CITY OF ALBUQUERQUE

RE: **Carmel Ridge Subdivision**
9154 Carmel Ave. NE
Engineer's Certification – Not Accepted
Engineer's Stamp Date: 3/1/17
Certification Dated: 6/20/18
Hydrology File: C20D075

Based on the submittal provided on 6/22/18, this Engineer's Certification cannot be approved for SIA Release or Pad Certifications until the following are addressed:

BEING A REPLAT OF LOT 29, BLOCK 3, UNIT 3, TRACT 2, NAA  
GRADING & DRAINAGE PLAN

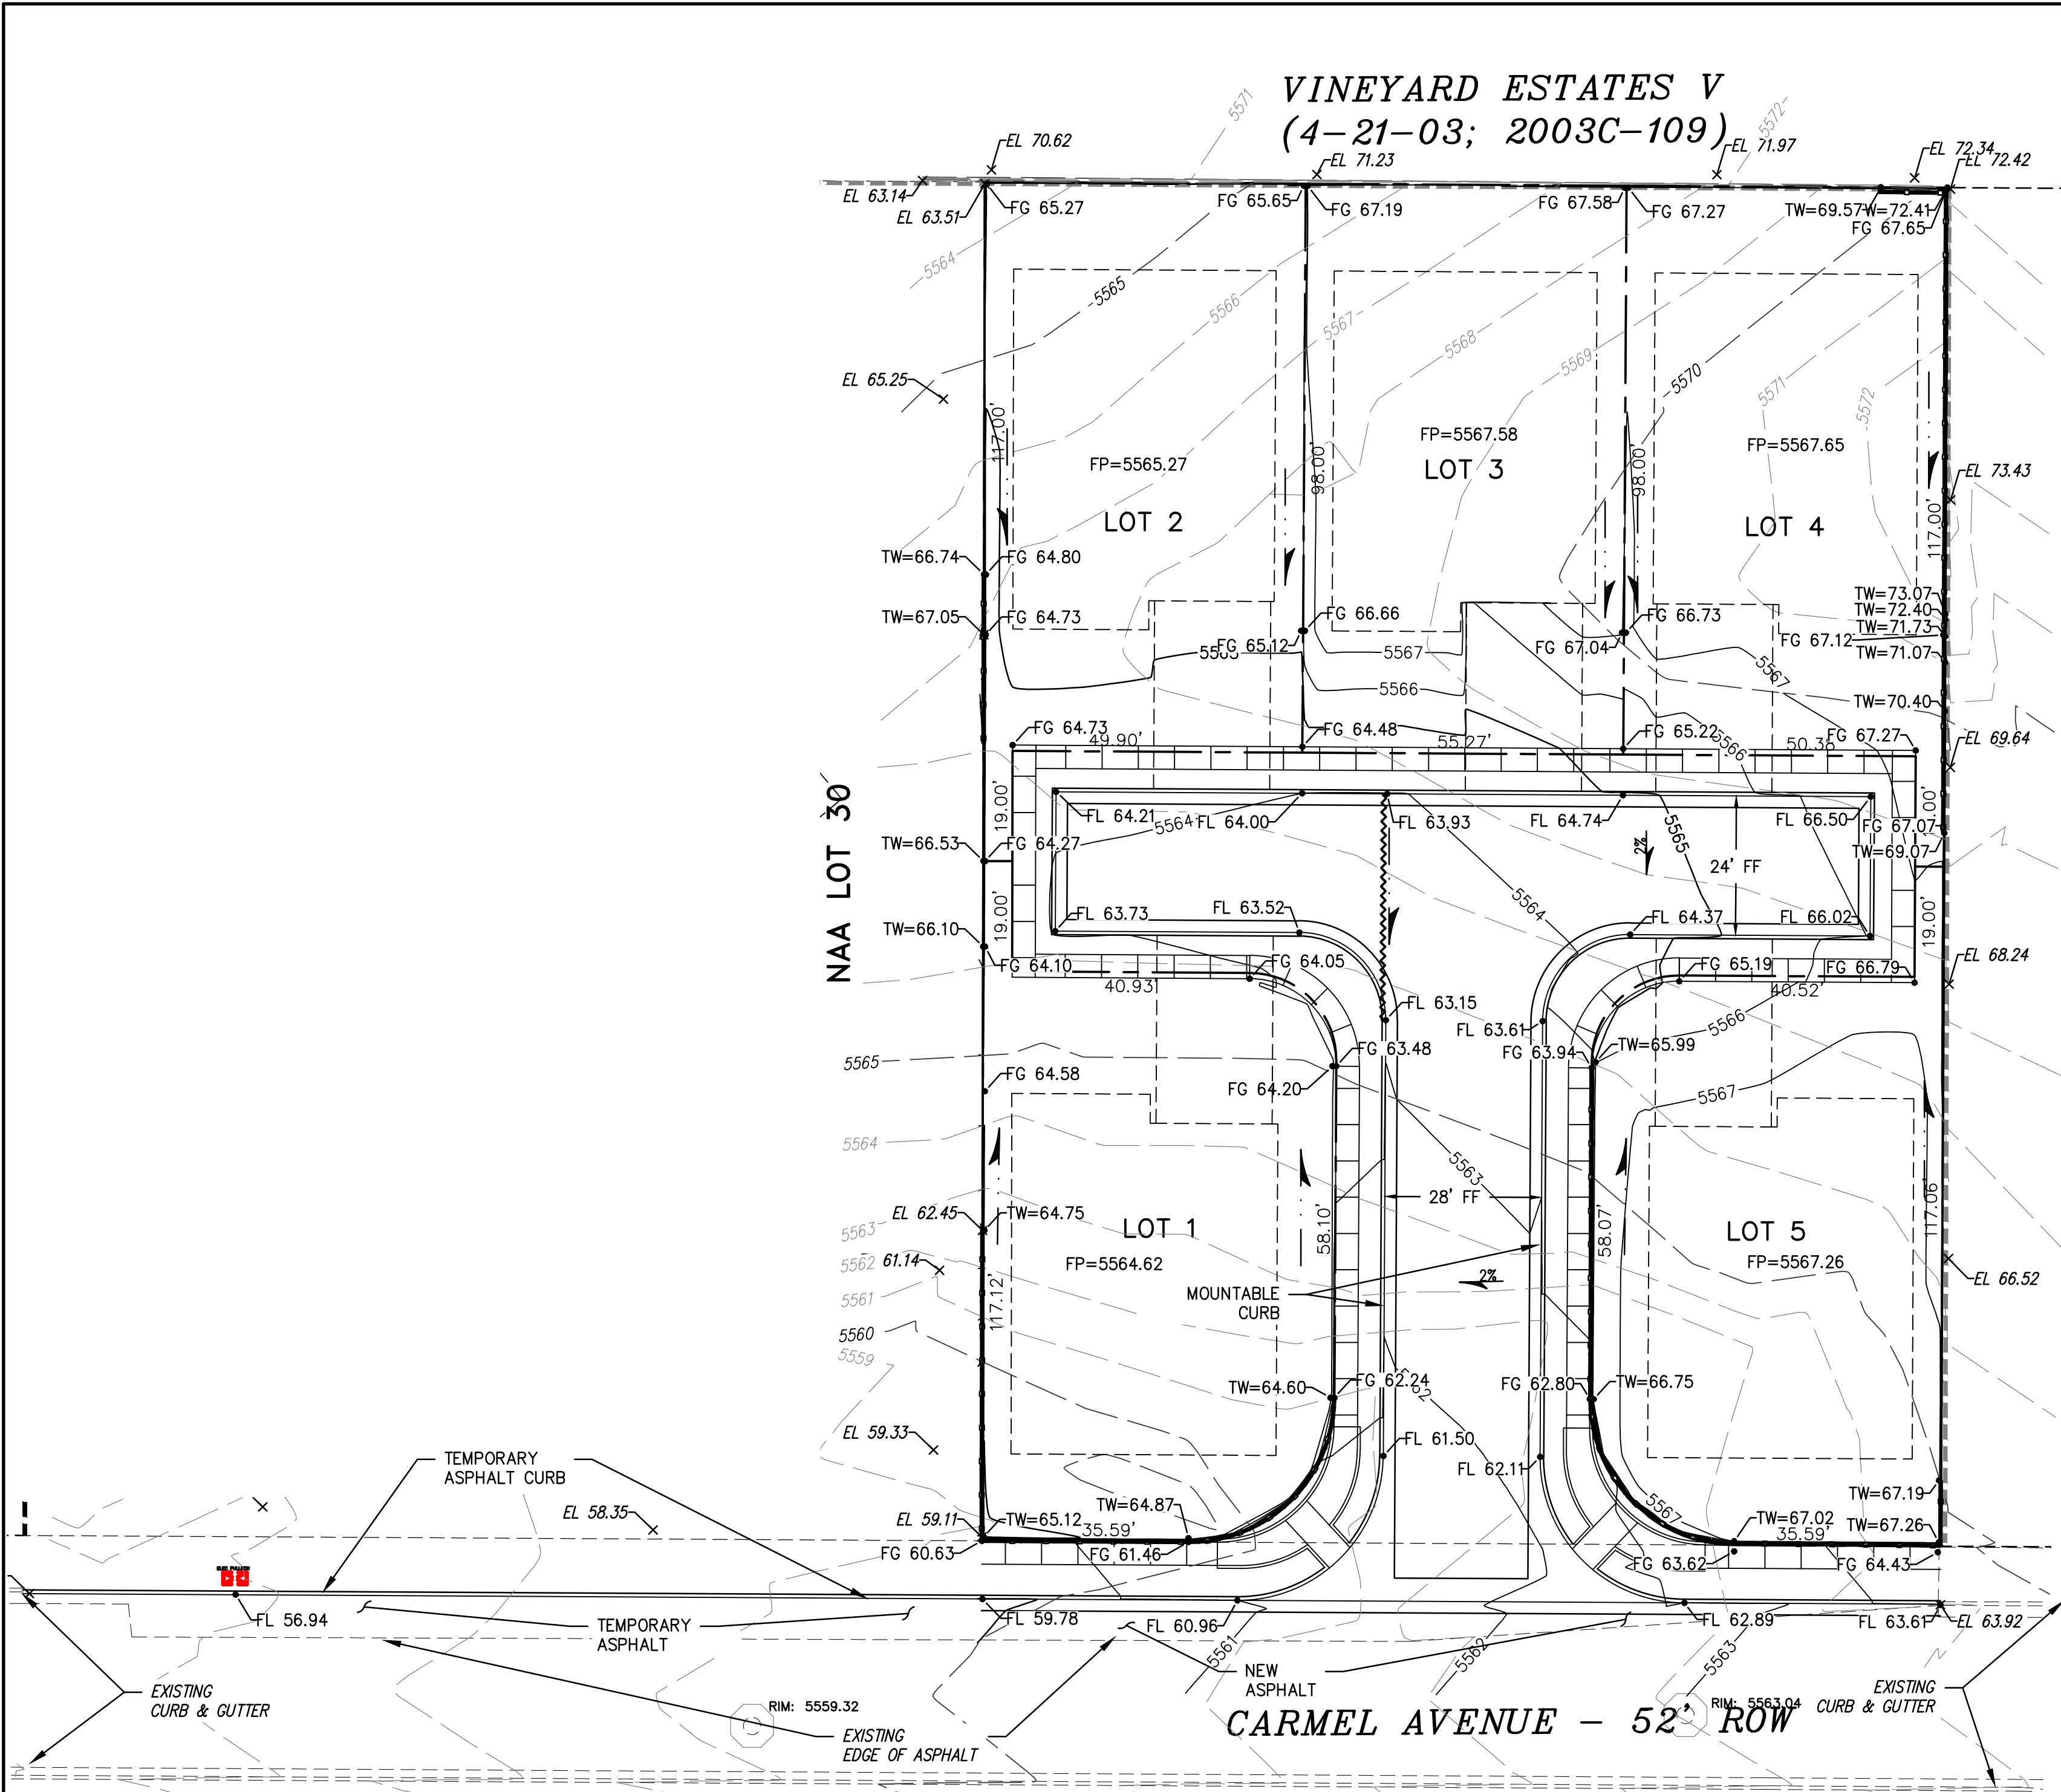
1. Corrective action must be taken along the eastern edge of this subdivision:
 - a. The excess fill will need to be removed and graded according to the approved plan. The recent grading is inadequate; the footer is still exposed at the end of the hammerhead and there is still excess fill placed against the garden wall.

- b. Provide complete survey data of both sides of the walls (both the existing garden wall and the new retaining walls) adjoining Visalia Way.
2. A retaining wall or stable slope (see DPM Ch. 22.5.A: *Slope Criteria*) is required between Lot 1 and Carmel Ridge Way. The slope is still erosive and there is still dirt over the sidewalk. If electing to use a new garden wall to stabilize this slope, it will need to be constructed and the post-construction survey will need to demonstrate that there is less than 2' of grade change and the flow line is not along the wall.

3. A retaining wall is required between Lot 3 and Lot 4 and Lot 3 needs to be graded to drain the front, not into Lot 4. If electing to use a new garden wall to serve this purpose, it will need to be constructed and the post-construction survey will need to demonstrate that there is less than 2' of grade change and the flow line is not along the wall.

Corrective grading has been completed on Lot 5, and additional as-built information has been included.

The slope is stable, and sediment control has been installed to protect the sidewalk. A wall will be constructed with development of the lot.
- 3) *A retaining wall is required between Lot 3 and Lot 4 and Lot 3 needs to be graded to drain the front, not into Lot 4.*

The condition of Lot 3 draining onto Lot 2 will be corrected with the installation of the property line wall in conjunction with house construction. Given the elevation difference of less than 2 feet, the wall was not noted as a retaining wall on the plan. Given that the wall has not yet been constructed, I have exclude Lots 2 & 3 from the certification.
